Ecological comments following submission of additional information (Bat and Bird Survey Report, Oct 2012)

Planning Application No: 3/2012/0539

Proposals: **Proposed installation of three endurance 50kw wind turbines 46m in overall height**

Location: **Carr Hall Garden Centre**

Figure 2: Location of surveyor for bat emergence survey (RK), activity survey transect route (red line) and location of automated detectors (SM2).

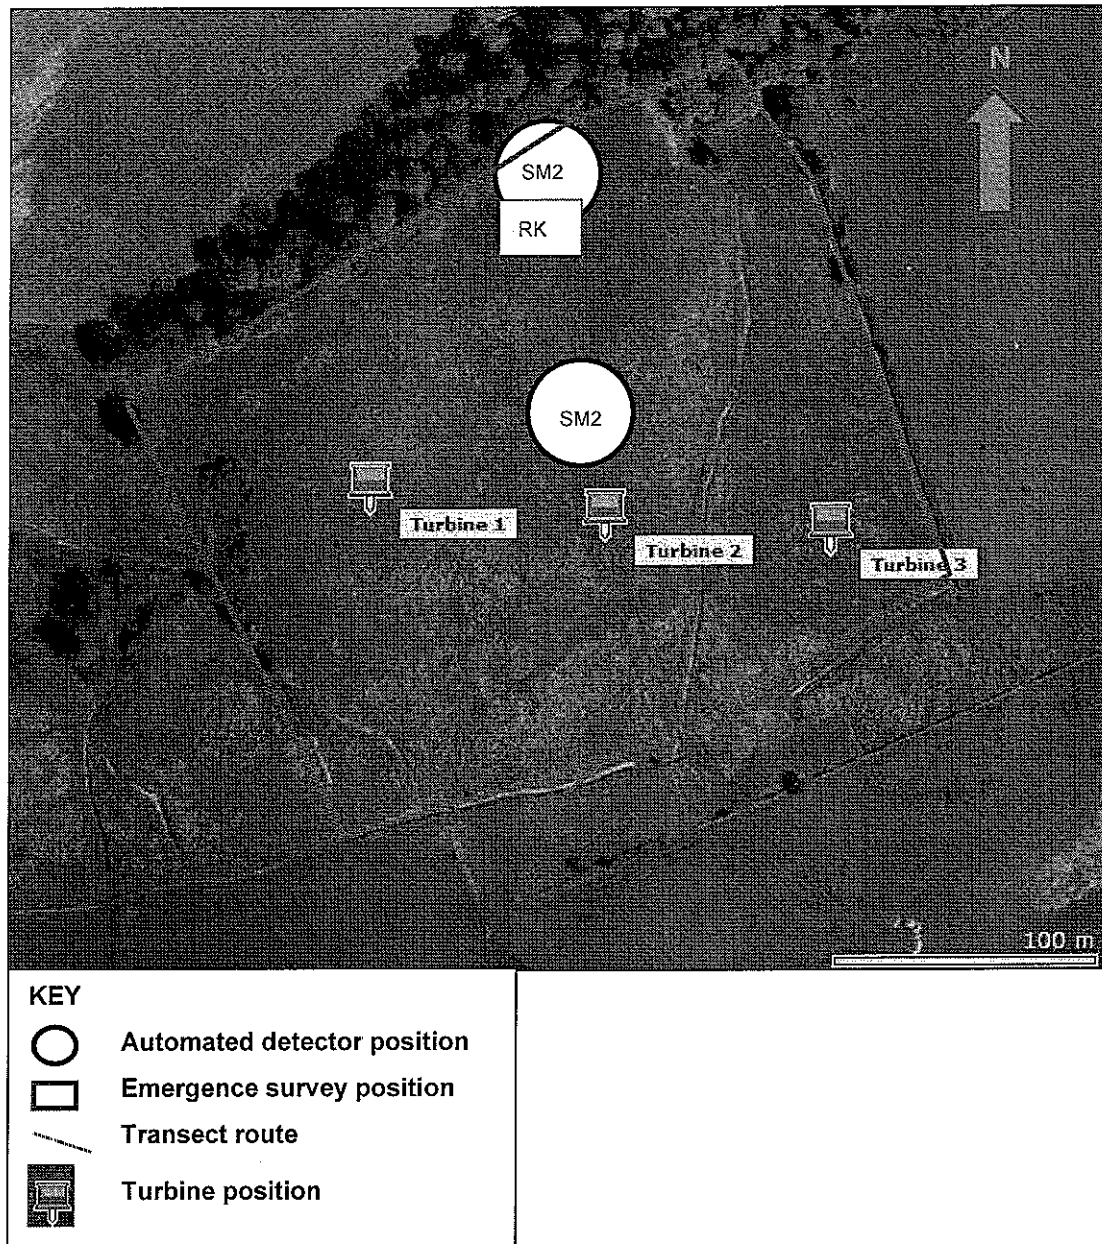
The surveys have identified that Common Pipistrelle, Soprano Pipistrelle and Noctule use the area of the proposed turbine locations. The Natural England TIN 051 states that, taking into account various factors including habitat preference and flight behaviour, Common Pipistrelle and Soprano Pipistrelle are at medium risk of adverse impacts (killing/injury) from turbines and that Noctule are at high risk. As TIN051 states, when assessing adverse impacts of wind turbines on bats there is a need to distinguish between (a) individual casualties and (b) mortality that affects populations. The submitted bat report appears to assess the risk only in terms of risk to bat populations, concluding that the risk to populations of the species recorded is low and therefore no mitigation measures are necessary. However, the provisions of the Habitats Regulations 2010 also make it an offence to deliberately or recklessly kill or injure a bat. This means that precautions must be taken to avoid the killing or injury of bats which is most unlikely to be permitted under the terms of the licence (taken from the NE Mitigation Guidelines). As individuals of bat species thought to be of medium

and high risk of injury/death from turbines use the area of the proposed turbines, it is reasonably likely that installation of turbines in this location would result in injury/death of individual bats. The applicant has not demonstrated that there would be no impacts on individual bats and therefore the applicant has not demonstrated that the proposed development would not result in a breach of The Conservation of Habitats and Species Regulations 2010.

If there is a good reason why the turbines cannot be located elsewhere, then adequate mitigation measures should be submitted **prior to determination of the application** in order to ensure impacts on individual bats are avoided / unlikely. For example:

- Through reducing the value of the field for foraging bats and replacement/recreation of the habitat elsewhere, with follow up monitoring in order to determine the need for additional mitigation measures.
- Through disengaging/preventing the turbine blades from moving during periods when bats are likely to be active in the area (if Ribble Valley Borough Council are satisfied that this would pass the condition tests and would be enforceable).

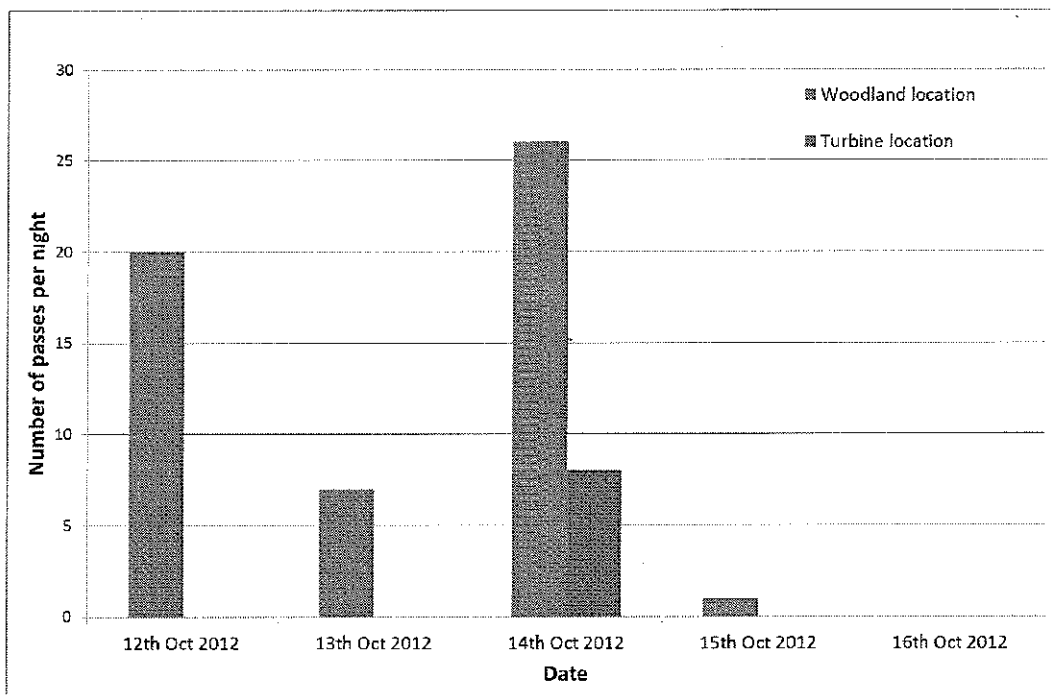
The bat activity surveys have confirmed that bats regularly use the location of the proposed turbines for foraging/commuting, with bat activity recorded during 6 out of 10 of the survey periods (table 4). Whilst I do not have information on the weather conditions during the survey, weather records accessible online indicate that temperatures were low in the county on some of the survey dates. It is therefore possible that bat activity would be higher during optimal weather conditions for bats.
